From: Neil Barker (AVLTD) [REDACTED]
Sent: 21 June 2021 10:31
To: Anita Gardner <Anita.Gardner@arun.gov.uk>
[REDACTED]
Subject: 1230_The_Willows_WA/28/21/HH

Willows West Walberton Lane Walberton BN18 0QS
Erection of rear extension and loft conversion following the demolition of existing conservatory
Arun Application ref: WA/28/21/HH

PROPOSED ROOF PLAN

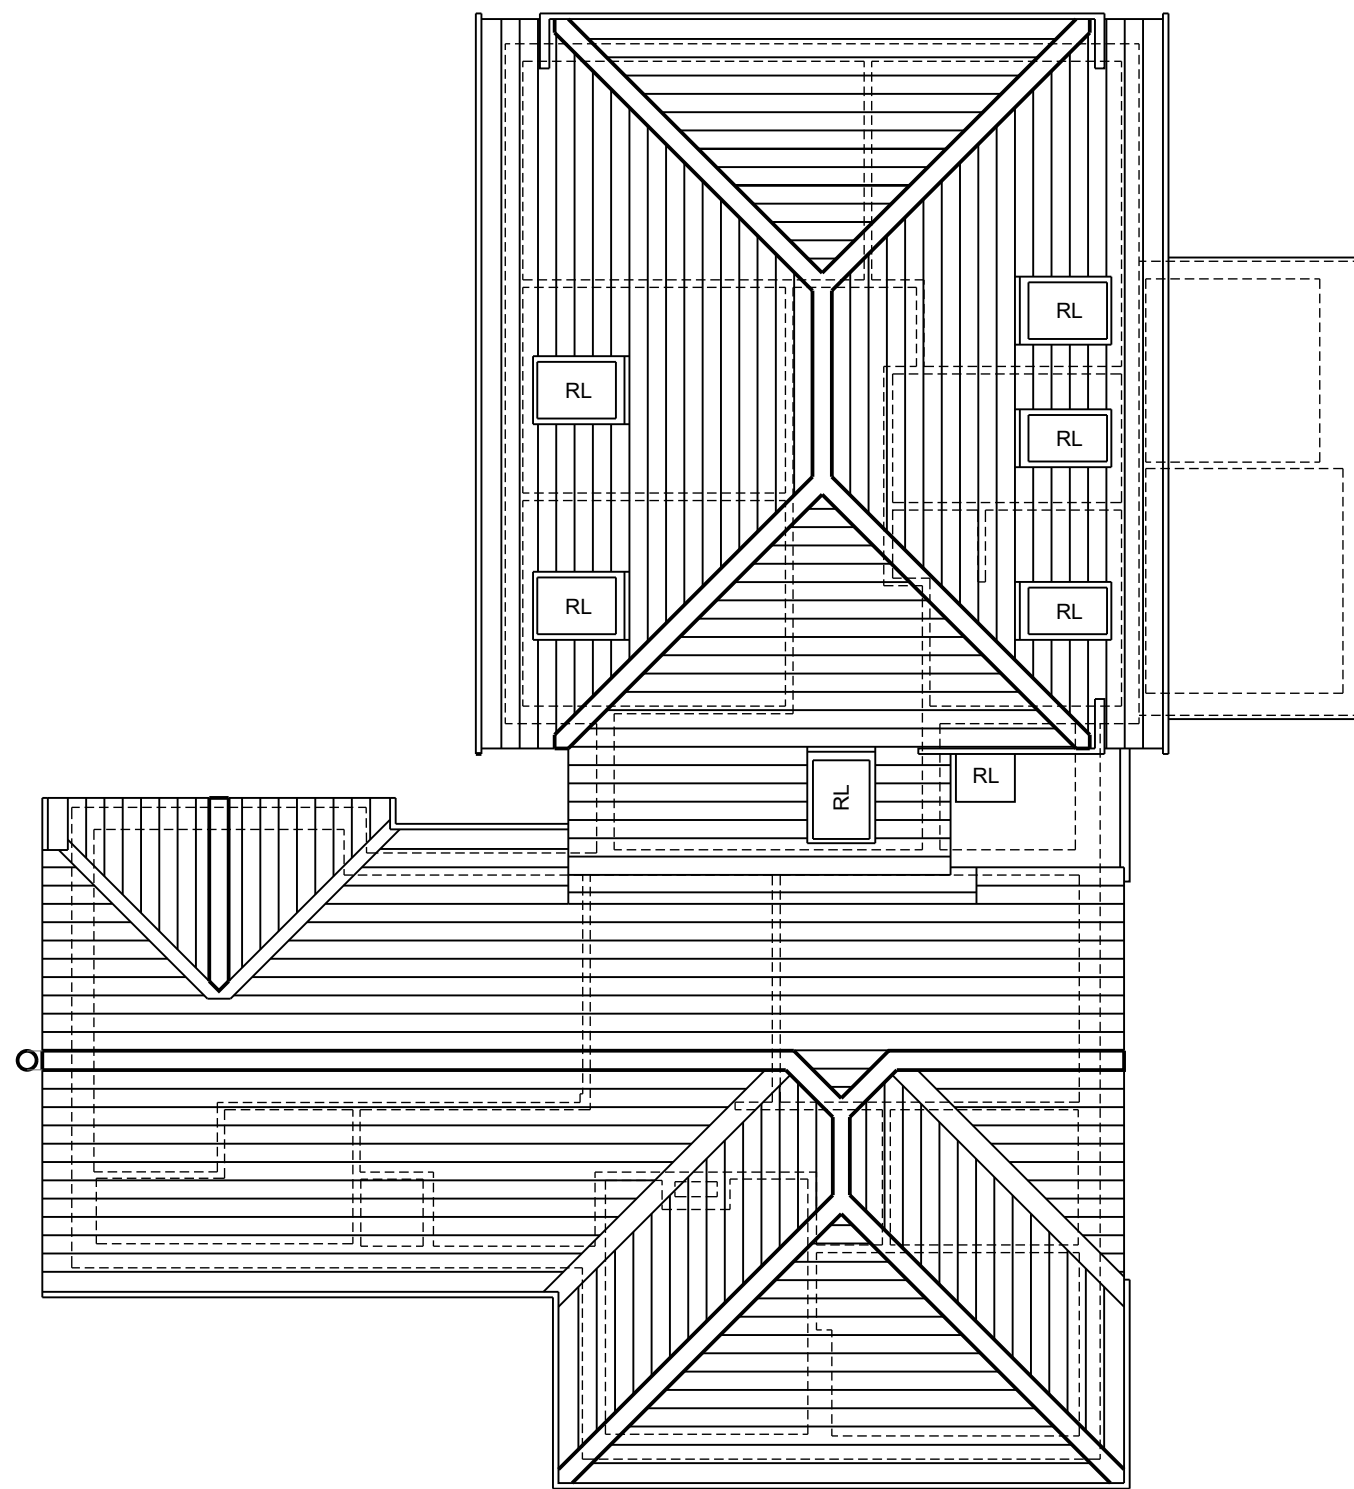
- Can we request your proposed Condition 3 regarding rooflights is applied to the West Elevation only with notes as follows:
 - West Elevation Rooflights are to rooflights to Ensuite and Bathroom that are closer to the boundary so the Condition seems fair and reasonable.
 - East Elevation Rooflights (the condition is not necessary / appropriate)
 - the wall is declared on drawing 1230_02 as 8.73m from the boundary . . . the rooflights being up the roof slope would be further than this declared distance so improve on this space separation.
 - as can be seen from photos attached there is mature planting to the Eastern Boundary (right hand side of photo 1271; left hand side of photo 1305) which combined with the distance

Please can you confirm the clarification above satisfies your proposed Condition 2 (and that this will not be required) . . . and that Condition 3 rather than being a blanket standard condition can be tailored to apply to the West Elevation only where it is appropriate. We accept Condition 4 does appropriately limit any further windows being added without consent.
